Rezoning Transportation Analysis

Petition Number: 2020-013

| Date | Description |
|----------|--------------|
| 02-24-20 | First Review |

RZ-1

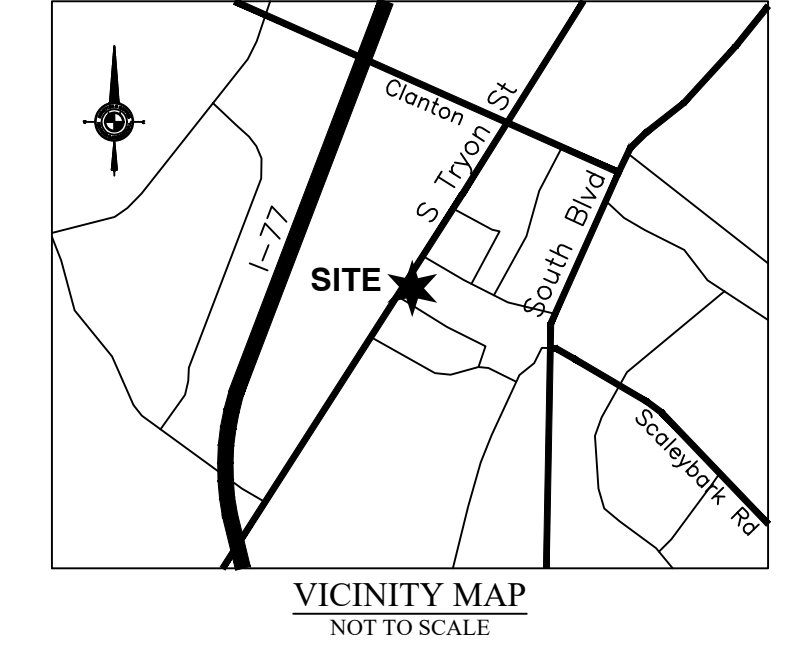
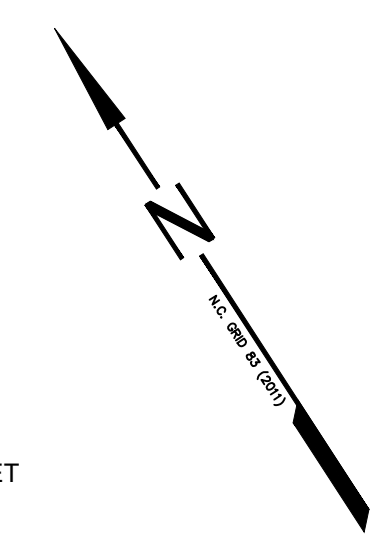
1. **Curbline** The proposed zoning district has a setback measured from back of the existing or proposed future curbline.
 - a. **South Tryon Street:** The future location of curb and gutter is 41 feet from road centerline, per the council adopted CDOT Streets Map.
 - b. **East Cama Street:** The future location of curb and gutter is 21.5 feet from road centerline, per the council adopted CDOT Streets Map.

The site plan should show the curb and gutter labeled and dimensioned from the centerline for each road.

3. The petitioner should revise the site plan and conditional note(s) to revise the East Cama Street future right of way that is proposed 35.5 feet from road centerline to dedicate 36.5 feet of right of way from centerline, per the council-adopted CDOT Streets Map and Charlotte Land Development Standards Manual (CLDSM) standard detail U-05-D – Commercial Wide Street Typical Section (TOD only). For clarification, the future curblines that is being referenced is now contained within the CDOT Streets Map, and not the Scaleybar Transit Station Area Plan. The site plan should label and dimension the right-of-way from the road centerline.

4. The petitioner should revise the site plan and conditional note(s) to revise the South Tryon Street future right of way that is proposed 65 feet from road centerline to dedicate 57 feet of right of way from centerline, per the council-adopted CDOT Streets Map. The site plan should label and dimension the right-of-way from the road centerline.

5. The petitioner should revise the site plan and conditional note(s) to commit to construct an 8-foot planting strip and 8-foot sidewalk, per the Scaleybar Transit Station Area Plan, with respect to the future curblines, along both South Tryon Street and East Cama Street. The Scaleybar Transit Station Area Plan remains as the reference for the streetscape requirements for this proposed rezoning.

6. The petitioner should revise the site plan and conditional note(s) to provide two curb ramps at the intersection of South Tryon Street & East Cama Street.

7. The petitioner should revise the site plan and conditional note of Section (C.Transportation.1.) to provide one access off of East Cama Street, via a CLDSM standard detail 1025.E - Type II Modified Driveway. NCDOT will not permit access off South Tryon Street.
8. The petitioner should revise the site plan to add a note specifying dedication and fee simple conveyance of all rights of way to the City before the site's first building certificate of occupancy is issued. CDOT requests right of way set at 2' behind back of sidewalk where feasible.
